**WELWYN HATFIELD BOROUGH COUNCIL
ASSISTANT DIRECTOR (PLANNING)**

DELEGATED APPLICATION

Application No: 6/2023/0787/HOUSE
Location: London Lodge Bedwell Park High Road Essendon Hatfield AL9 6HY
Proposal: Erection of single storey rear extension following demolition of existing rear extension, new vehicle entrance and associated landscaping
Officer: Ms Elizabeth Mugova
Recommendation: Granted

1 Site Location Plan - London Lodge - Proposed
Scale: 1:200

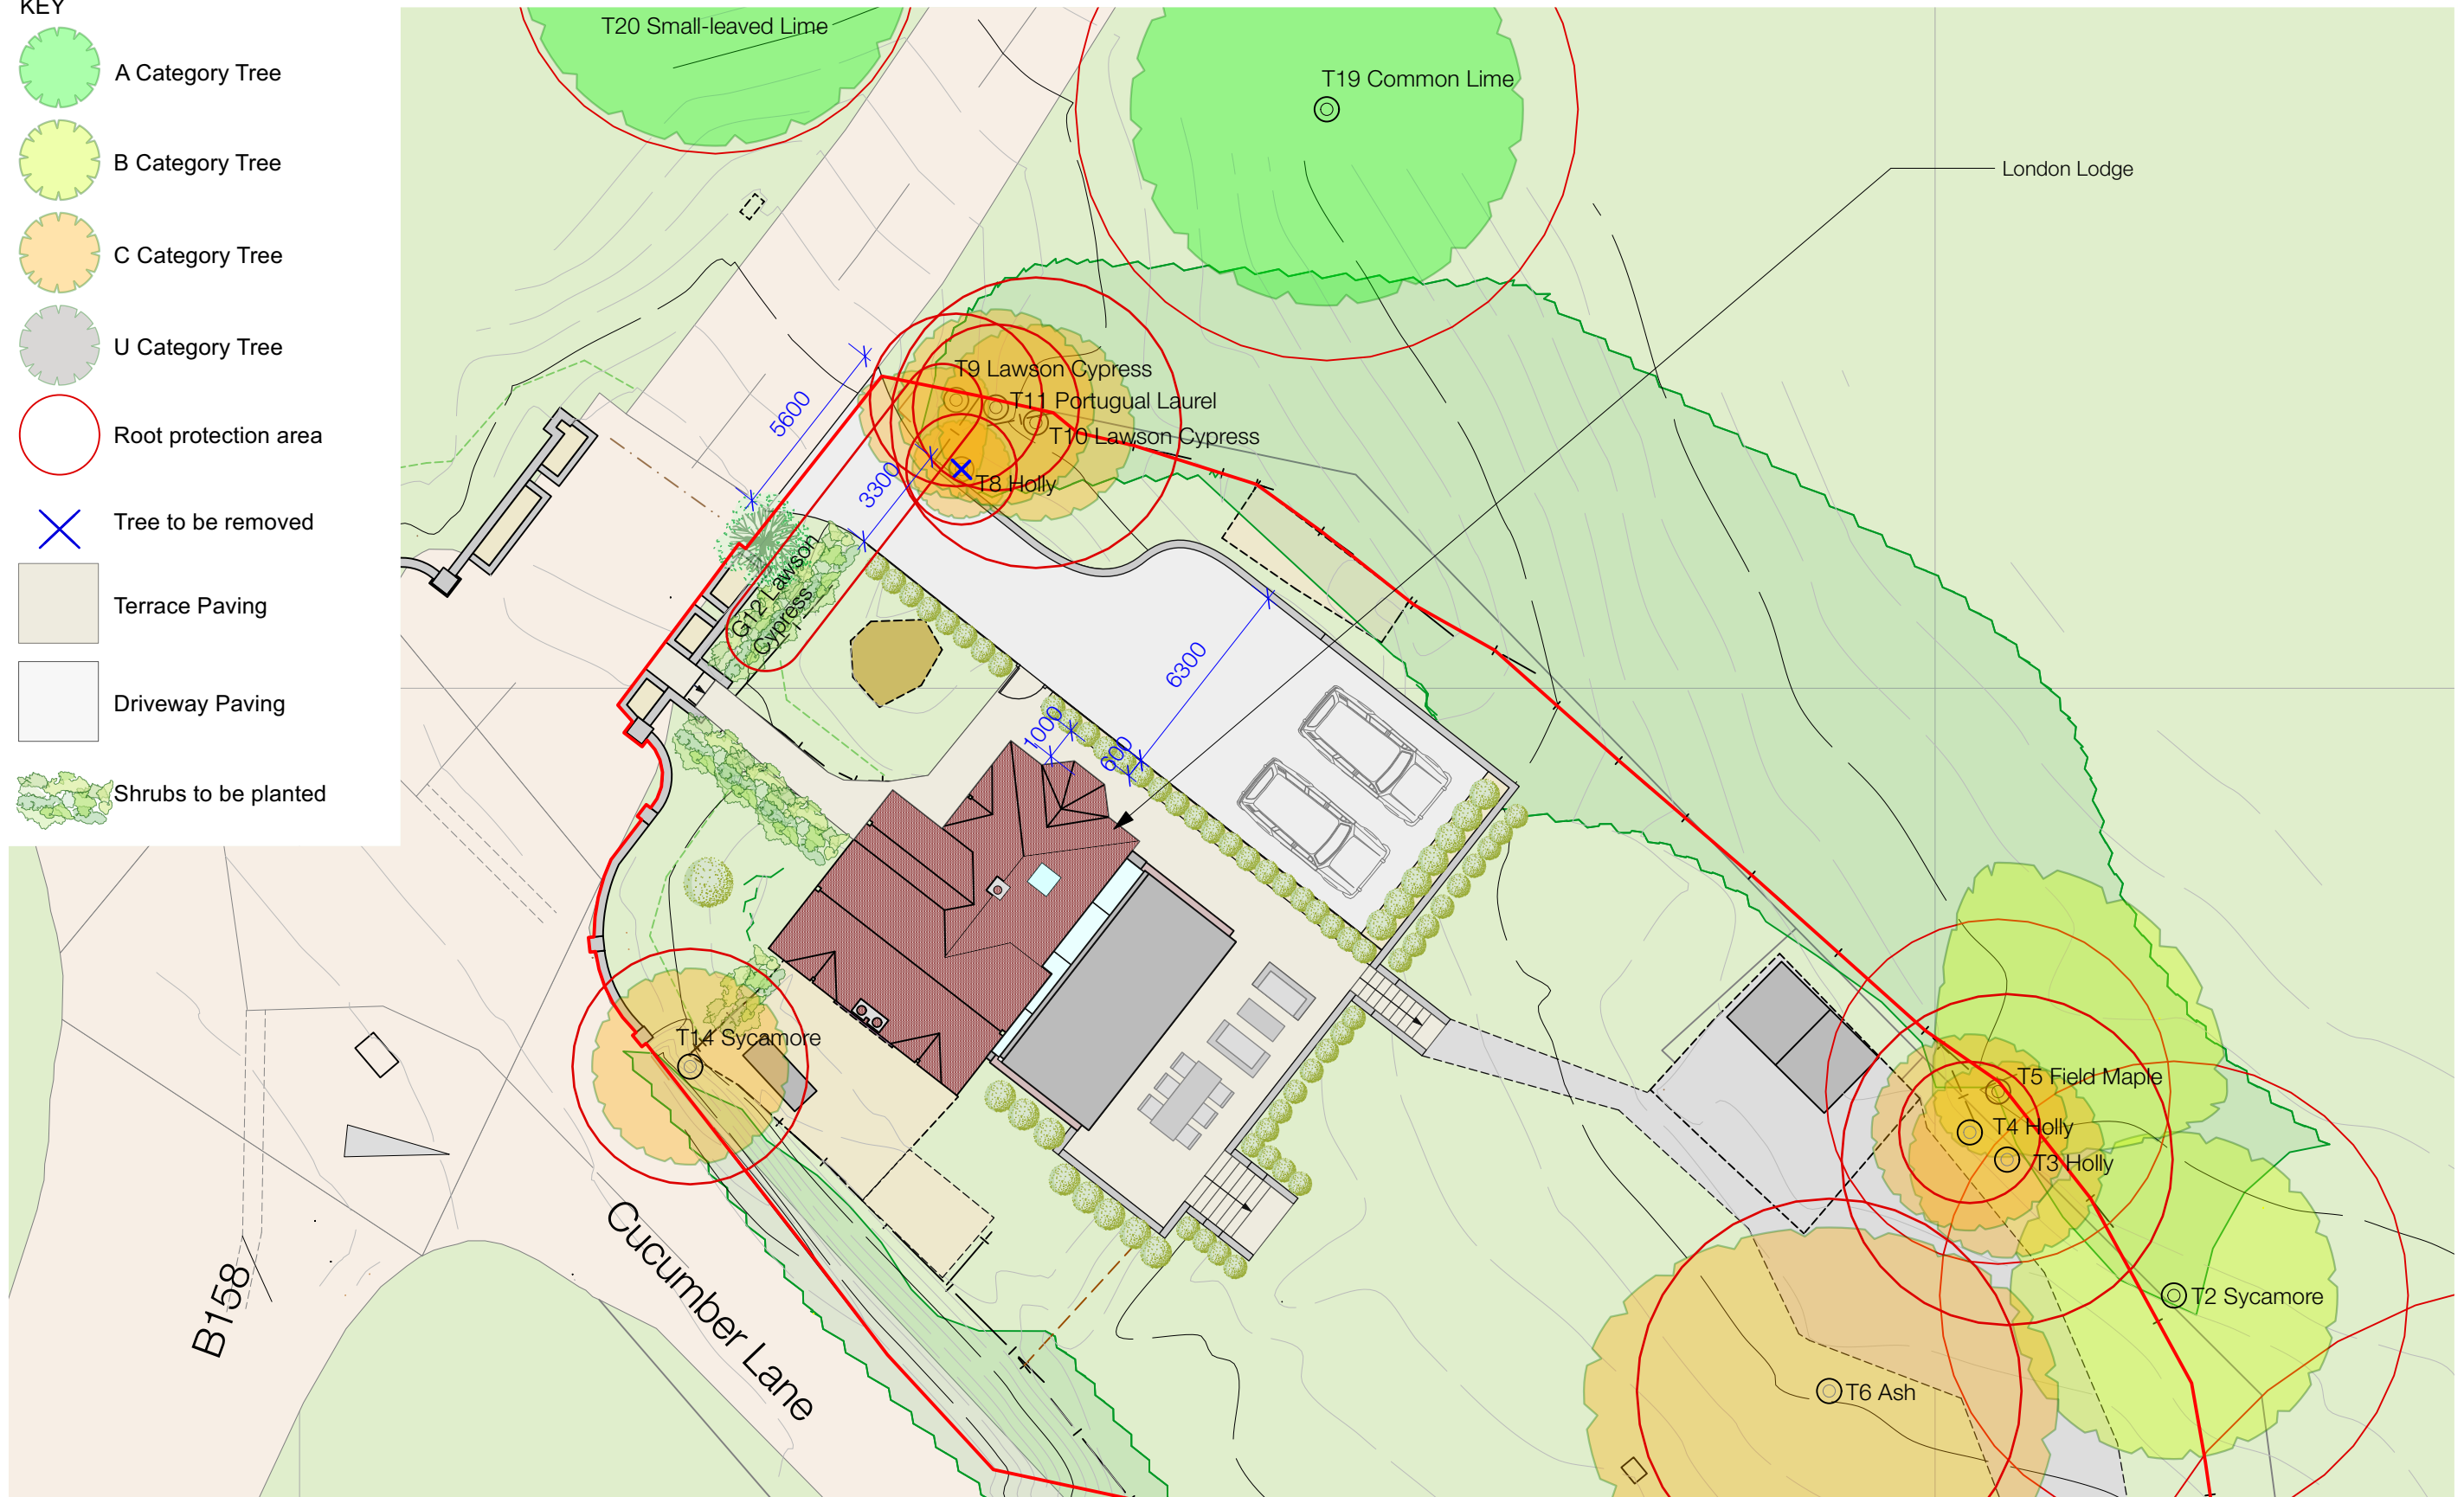
Also, planning permission is sought for new access to the north of the Lodge from the main driveway to Bedwell Park House. The proposal will incorporate hard and soft landscaping which includes black painted steel fencing, driveway paving and shrubs. Whilst the proposed landscaping is not likely to impact on the setting of neither the listed building nor the setting of Bedwell Park House, it has been considered necessary and reasonable to require details of landscaping to be submitted to and approved in writing by the Local Planning Authority. The scheme of landscaping should show the type and extent of trees, planting to be retained and removed, specifications of species and sizes and hard landscape features. This would be required to maintain and enhance the visual character of the area in accordance with local and national policies.

7. No soft or hard landscaping works shall take place until full details on a suitably scaled plan of both hard and soft landscape works have been submitted to and approved in writing by the Local Planning Authority. The development shall not be carried out other than in accordance with the approved details.

- (a) means of enclosure and boundary treatments
- (b) hard surfacing, other hard landscape features and materials
- (c) planting plans, including specifications of species, sizes, planting centres, number and percentage mix, and planting methods and aftercare.

A Proposed Roof Plan
PL13 1:100

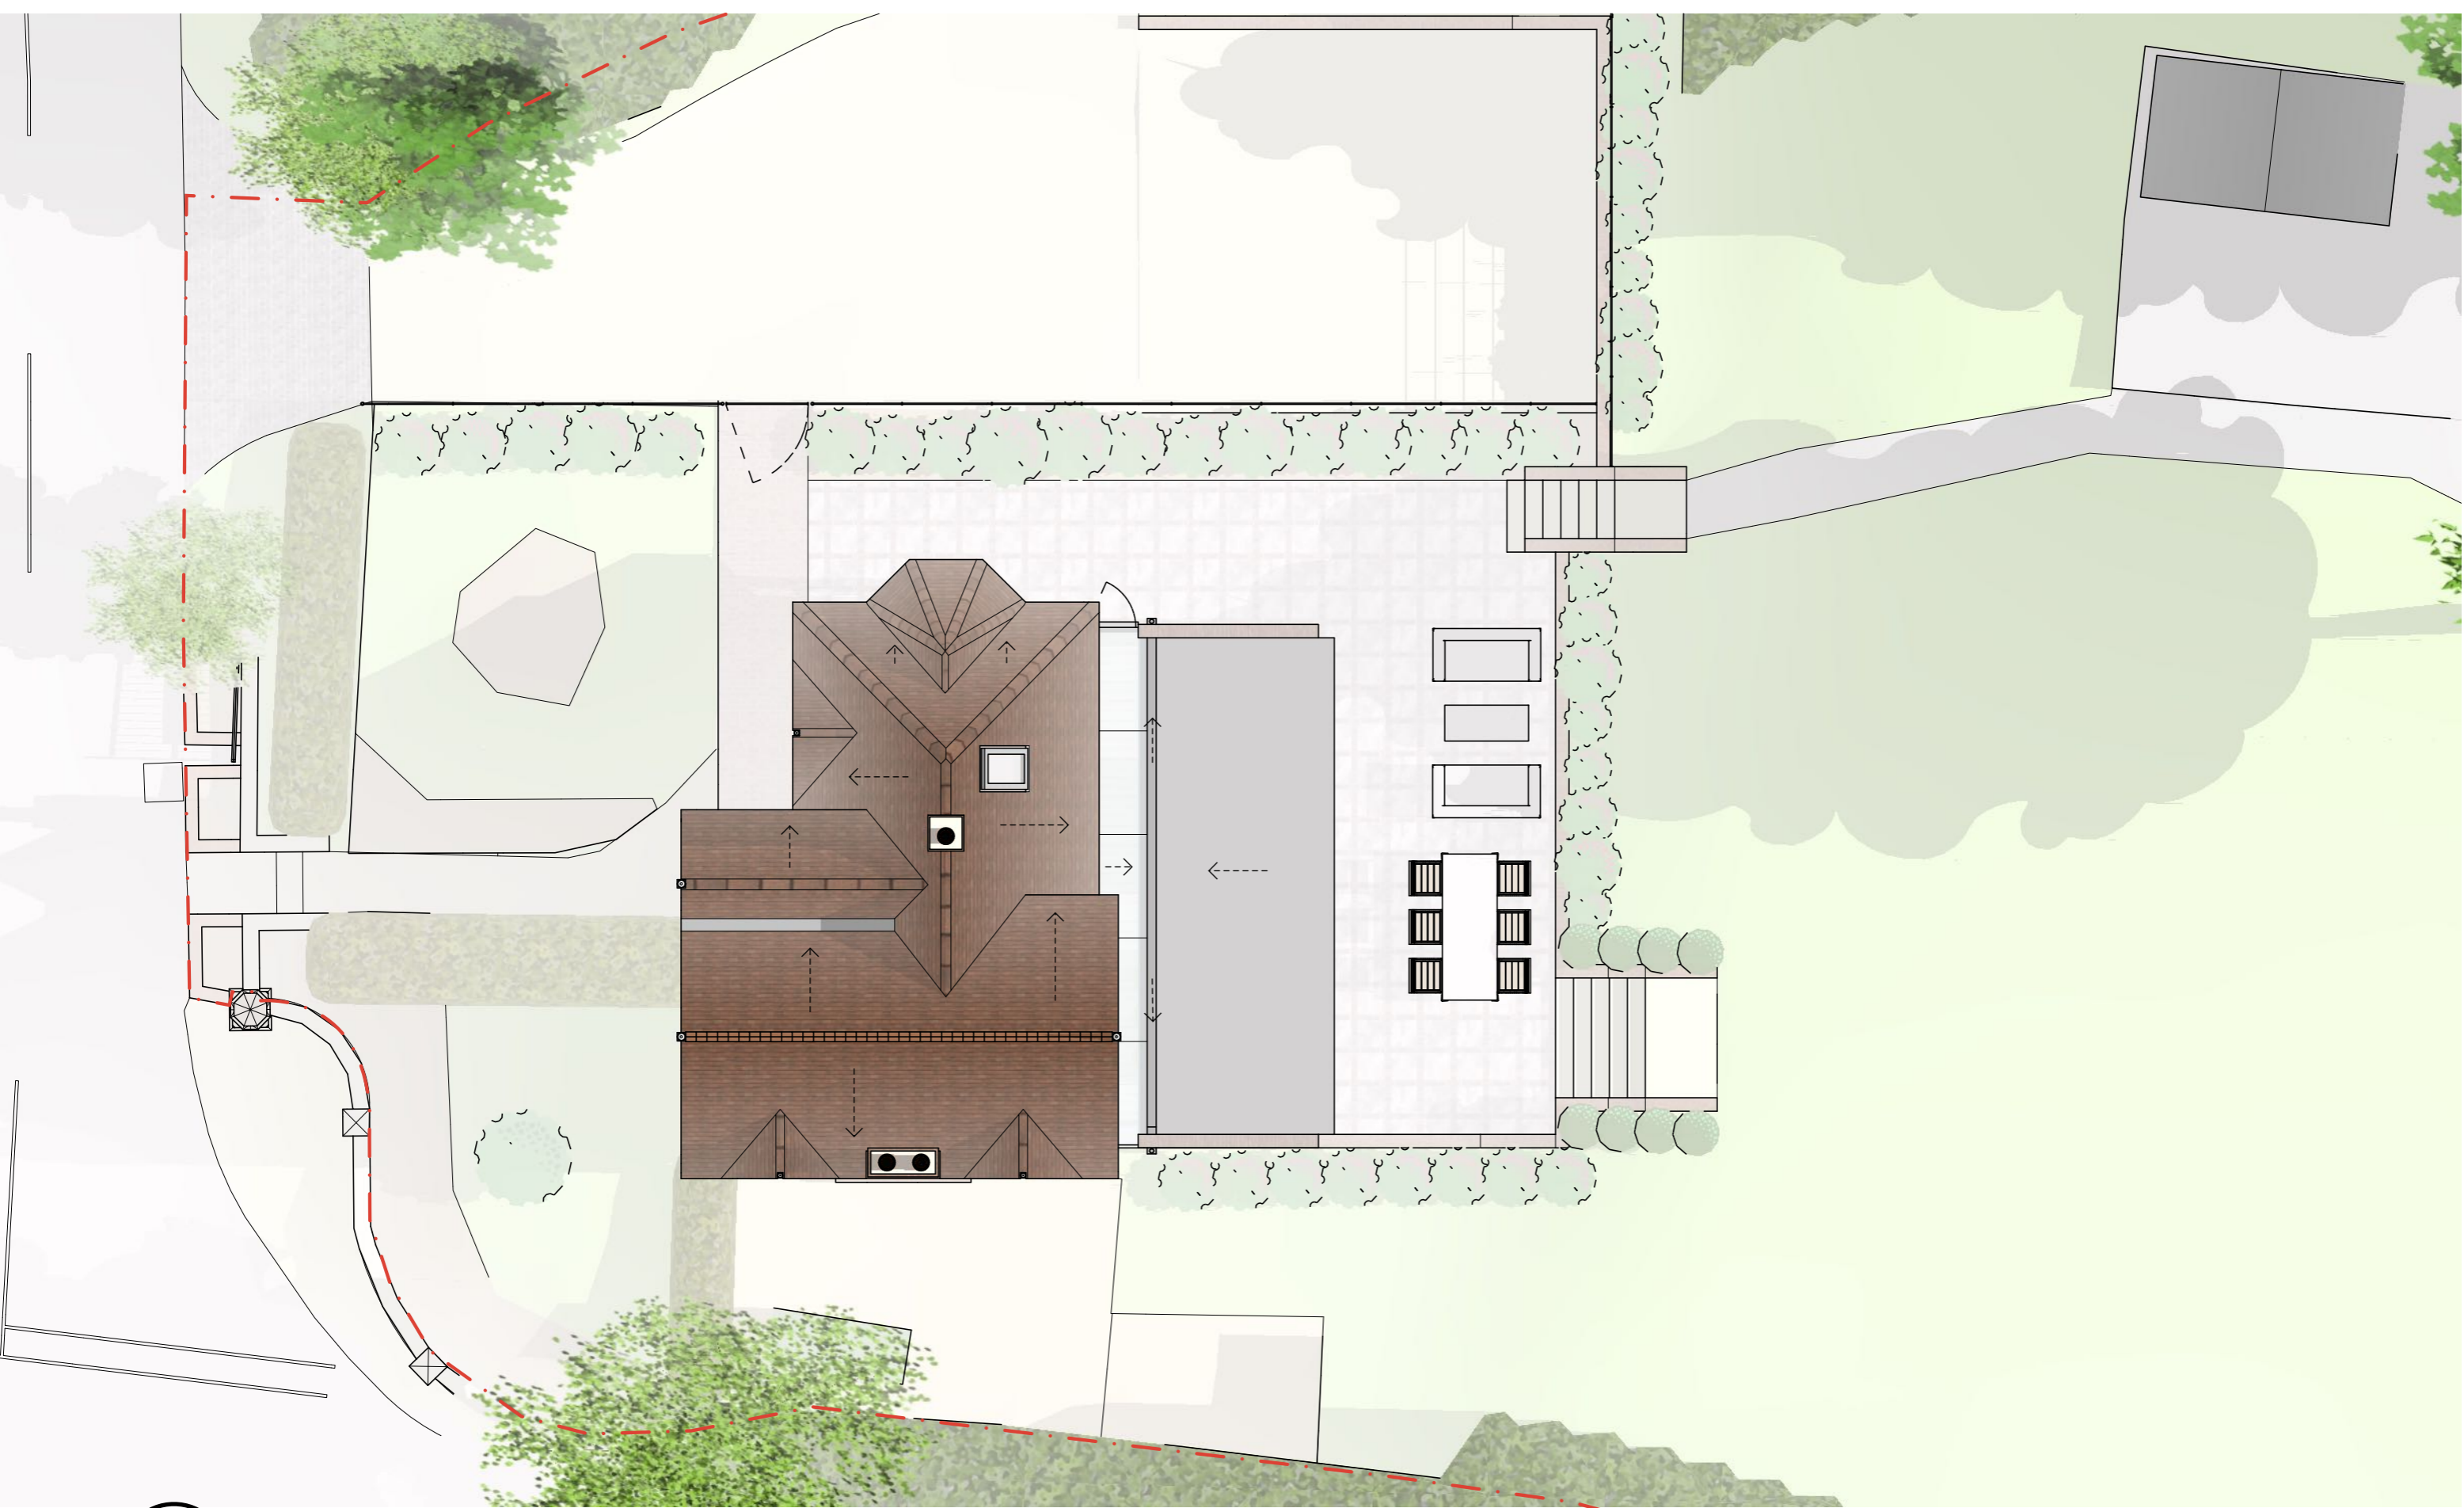
In addition to mathematical calculations the visual impact of the extensions has to be considered. The proposed single storey rear extension has been sensitively designed and is now set down, appearing subordinate towards the host dwelling. As such, the proposal now better reveal elements of architectural interest of the host property. It is therefore considered that the proposal would not impact on the character and appearance of the listed building and the surrounding area.

1. Following the removal of the existing extension, details of the treatment of the wall below the original eaves and above the new extension shall be submitted to and approved in writing by the Local Planning Authority prior to any alterations to this wall taking place. The development shall not be carried out other than in accordance with the approved details.

A Proposed Side Elevation (NE)
 PL17 1:100

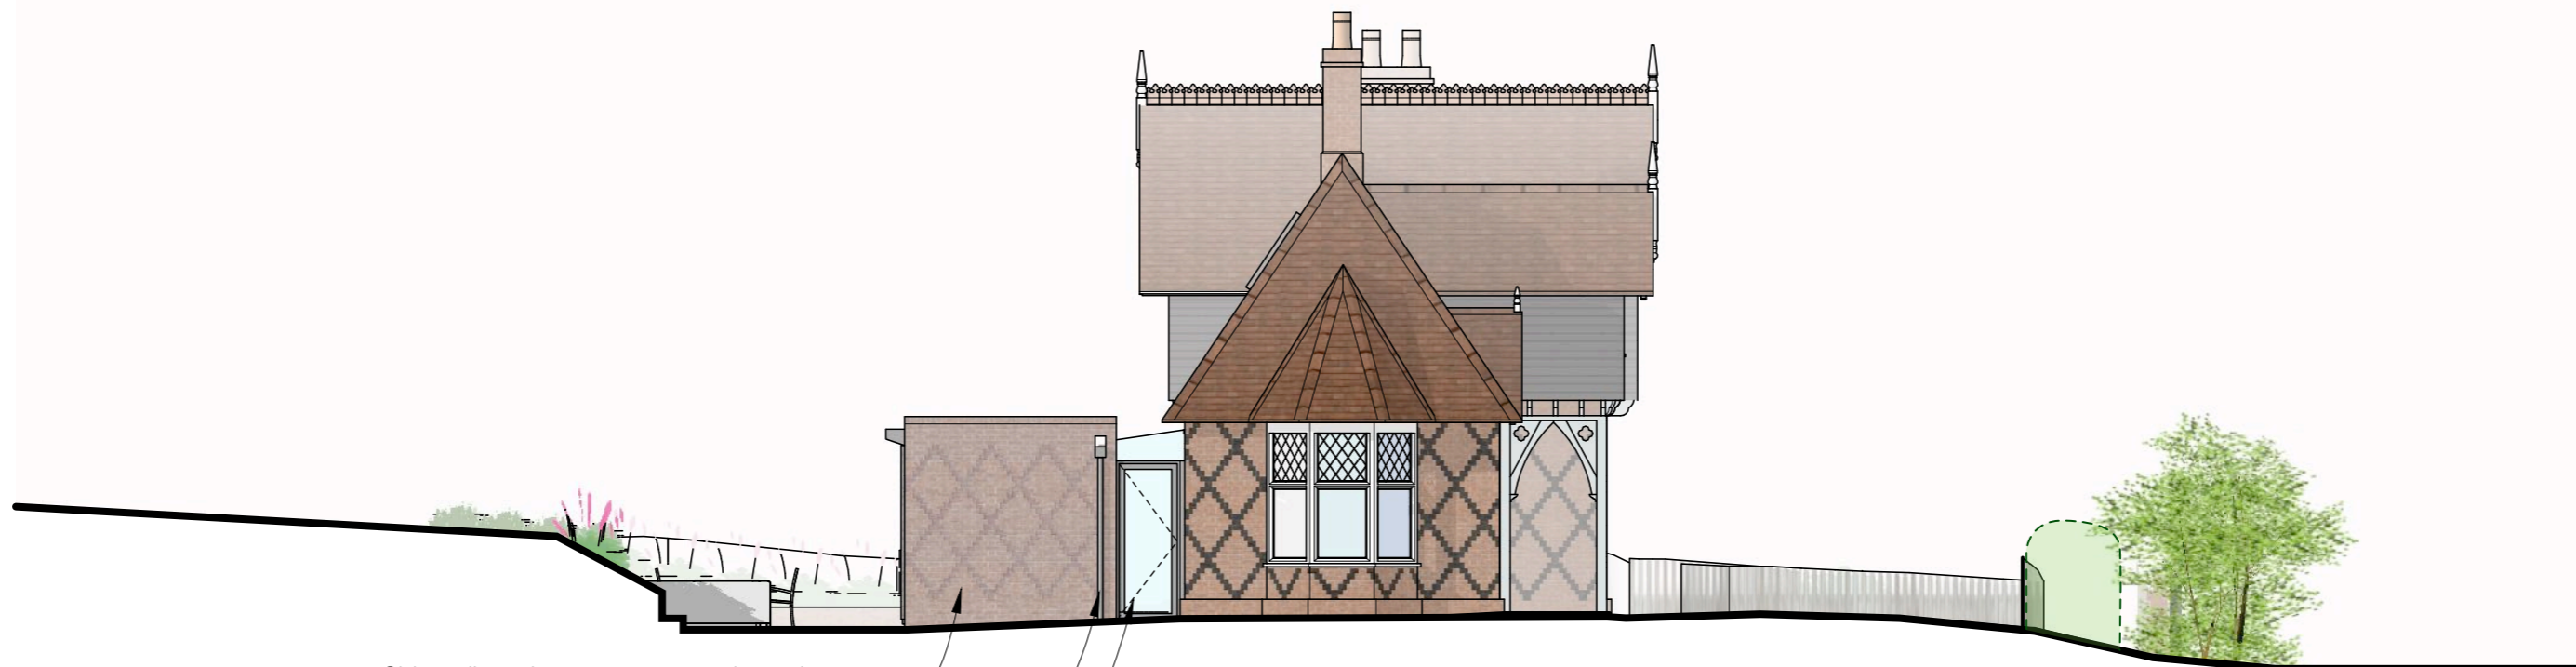
It is proposed to connect the extension to the host dwelling with a narrow glazed link which provides a break between the original Lodge and the proposed extension, particularly when the flank (north east) elevation is viewed from the driveway to Bedwell Park House. It is not considered that the link would impact on the setting of the Lodge subject to a condition requiring details of the junction of the

link with the Lodge being submitted to and approved in writing by the Local Planning Authority.

5. Prior to installation of the glazed link, additional drawings of the junction between the existing house and the glazed link of the rear extension shall be submitted to and approved in writing by the Local Planning Authority. The development shall not be carried out other than in accordance with the approved details.
